# MARIAH TRAIL FILING NO. 1

A PORTION OF THE NORTHWEST QUARTER OF SECTION 7,  
TOWNSHIP 11 SOUTH, RANGE 65 WEST, OF THE 6th PRINCIPAL MERIDIAN,  
EL PASO COUNTY, COLORADO.

PCD FILE NO. SF2315

FINAL PLAT  
OWNER: THOMAS D KIRK JR  
19205 MARIAH TRAIL, CO.SPR. 80908

MARIAH TRAIL FILING NO. 1

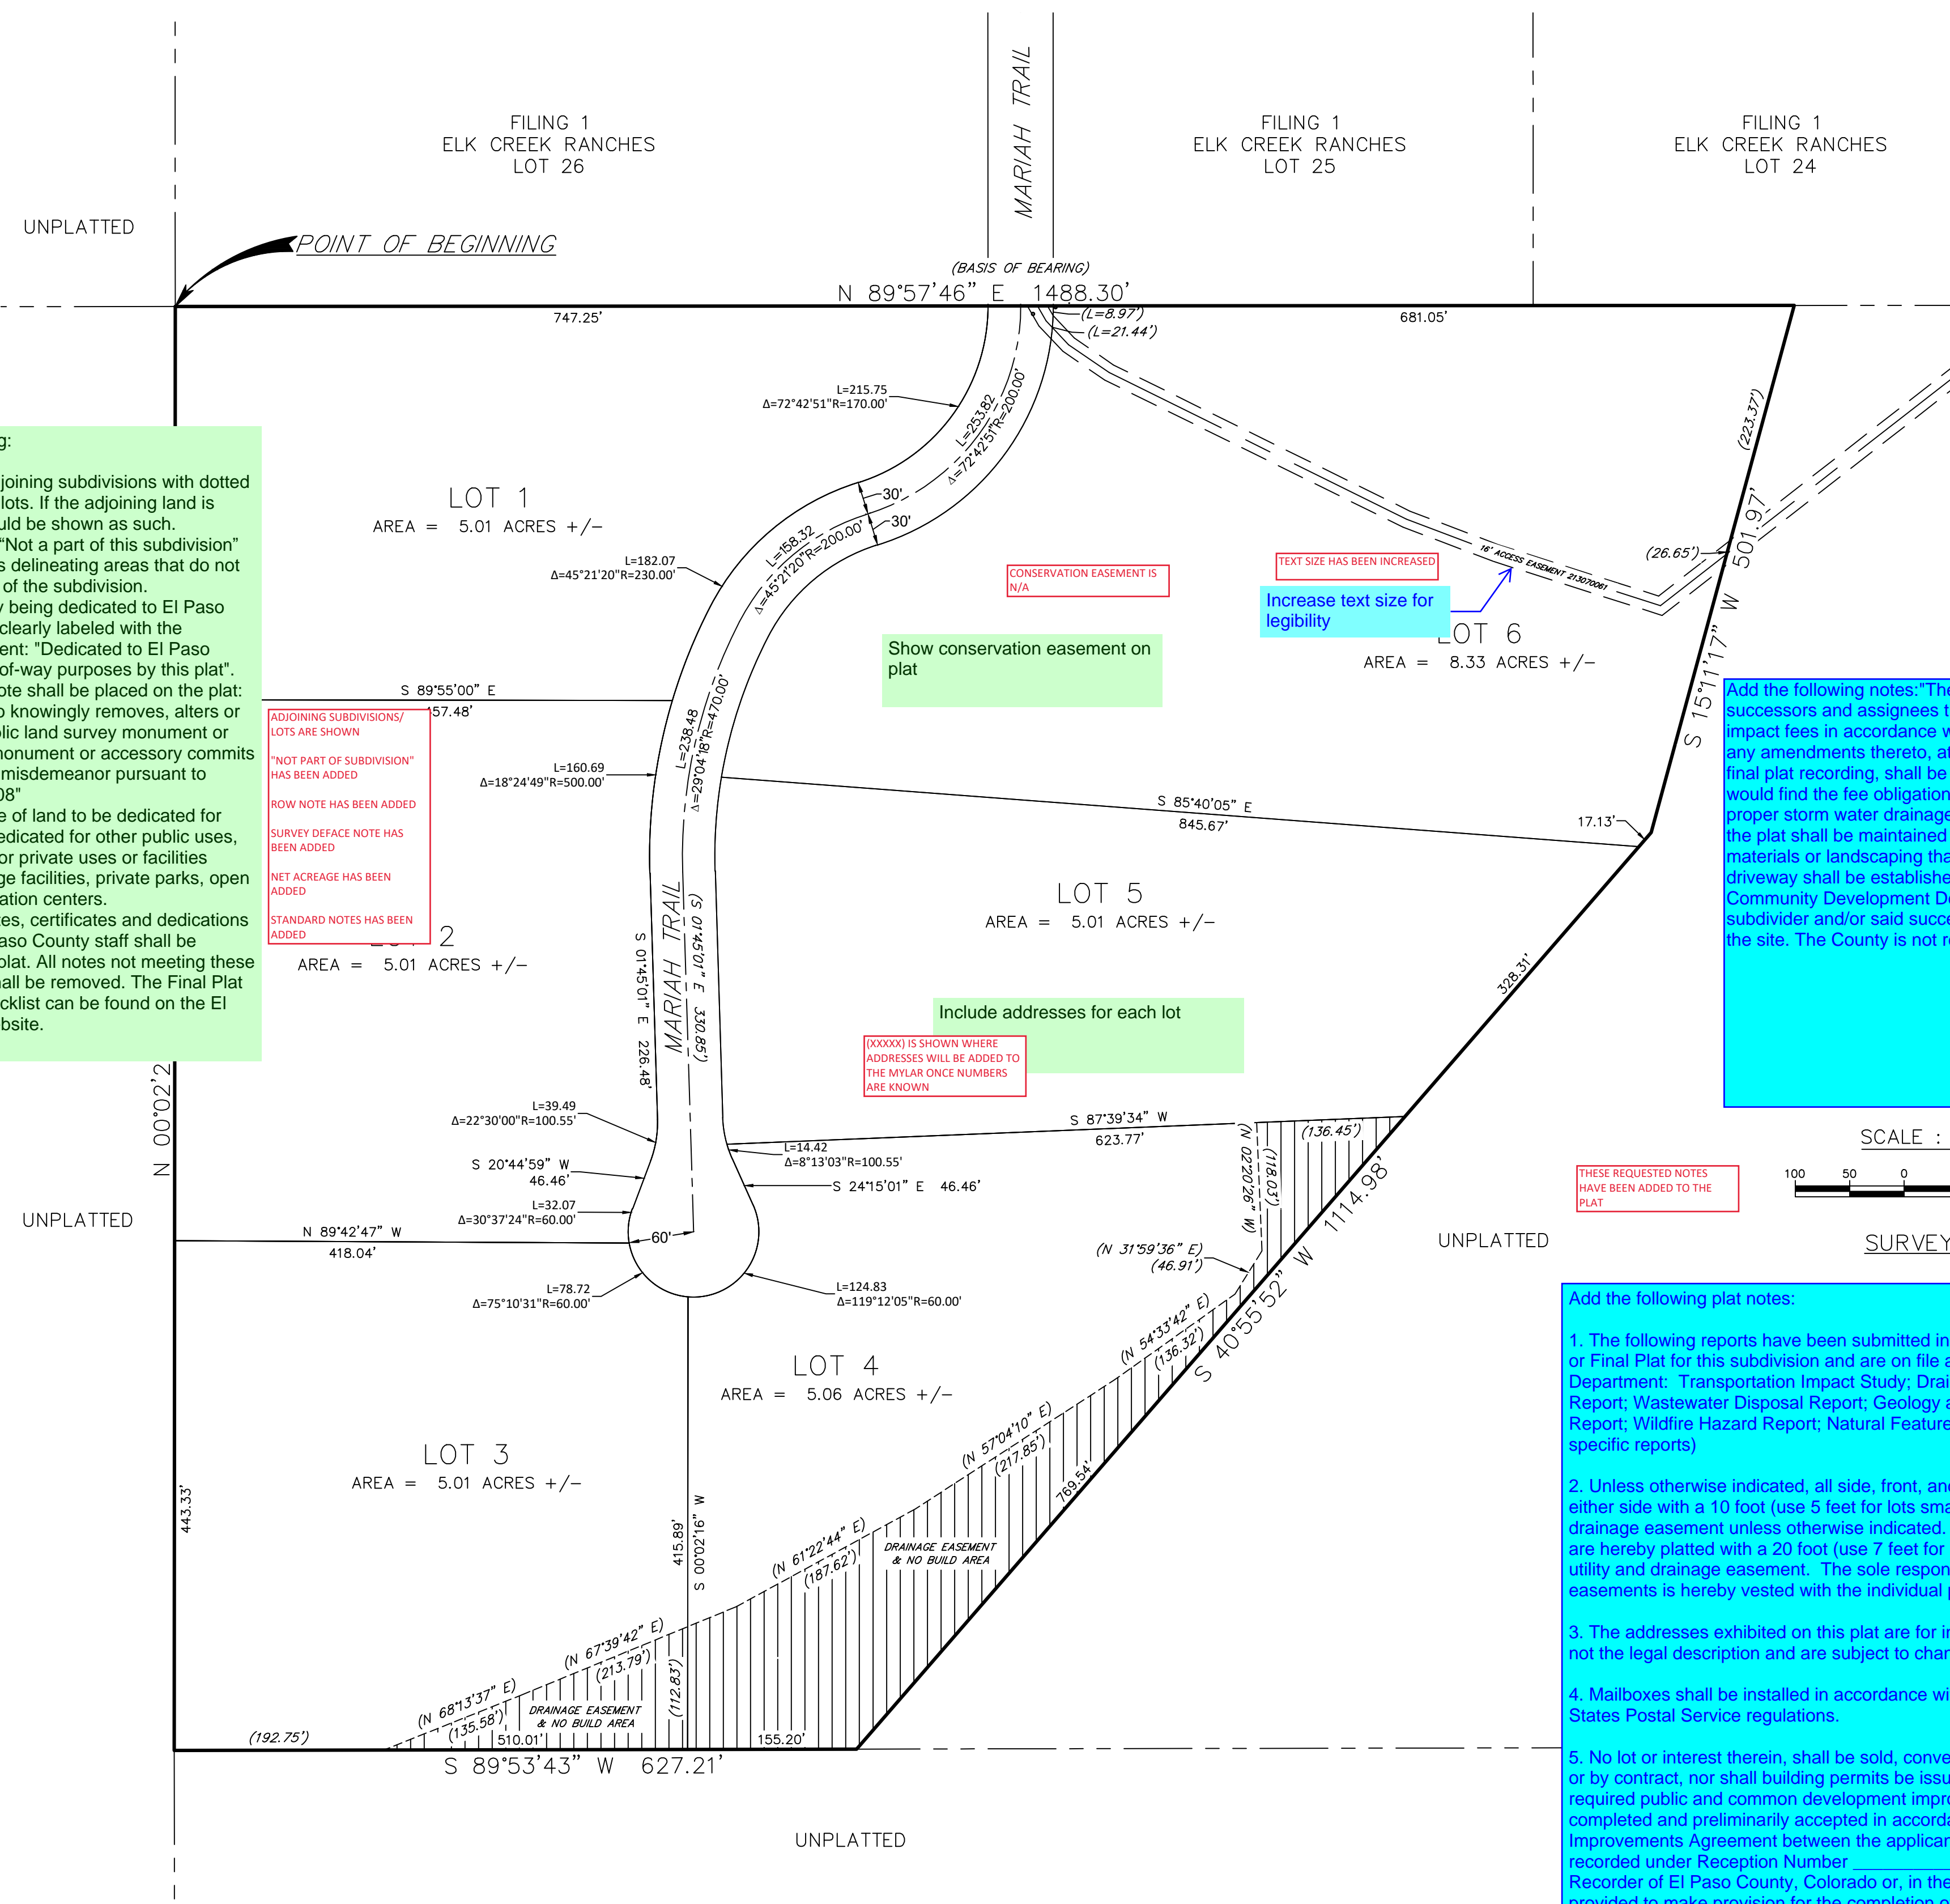
You can only access 3 lots off a driveway per the LDC. You are currently accessing a minimum of 4 lots with the access easement. A road needs to be provided or each lot needs direct access to Mariah Trail.

Lot 5 comes out to 4.92 acres when we exclude the flag pole

MARIAH TRAIL FILING NO. 1

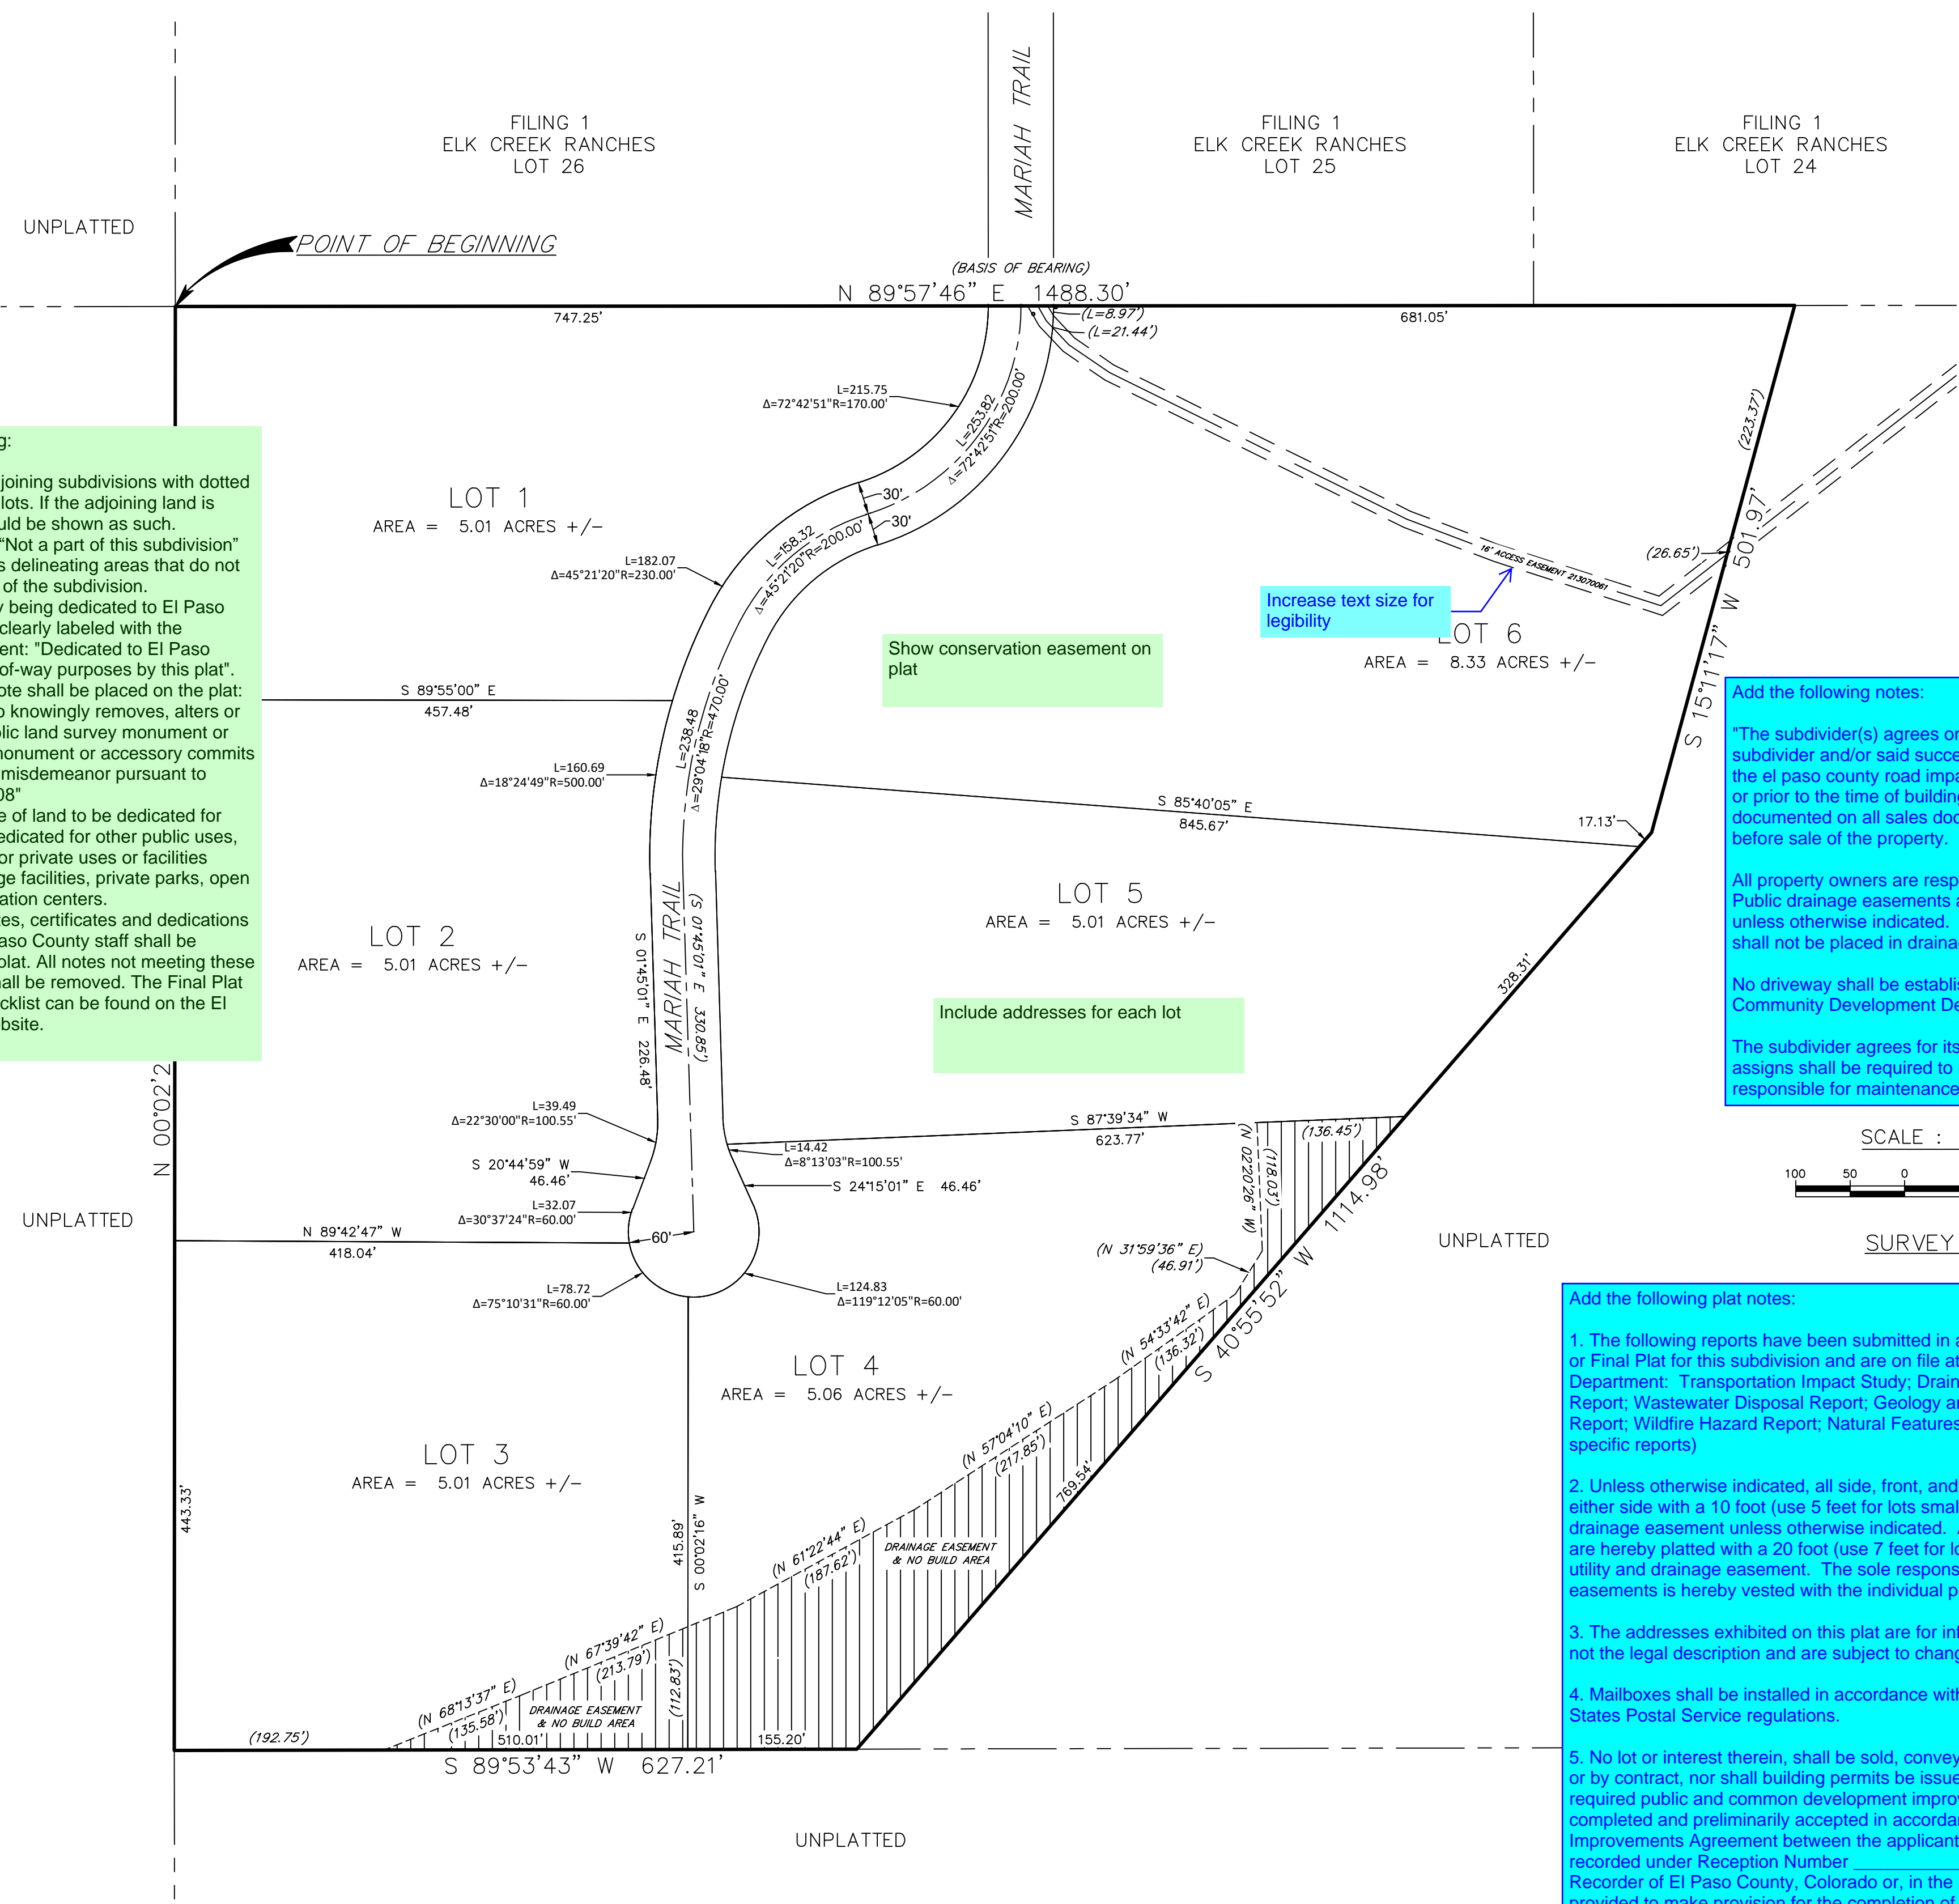
Please revise the note such that Lot 3 and Lot 2 are taking access easement and Lot 5 & 4 are taking access from another separate access easement.

FYI: max. 3 lots may access a single driveway.

revise to include both access easements
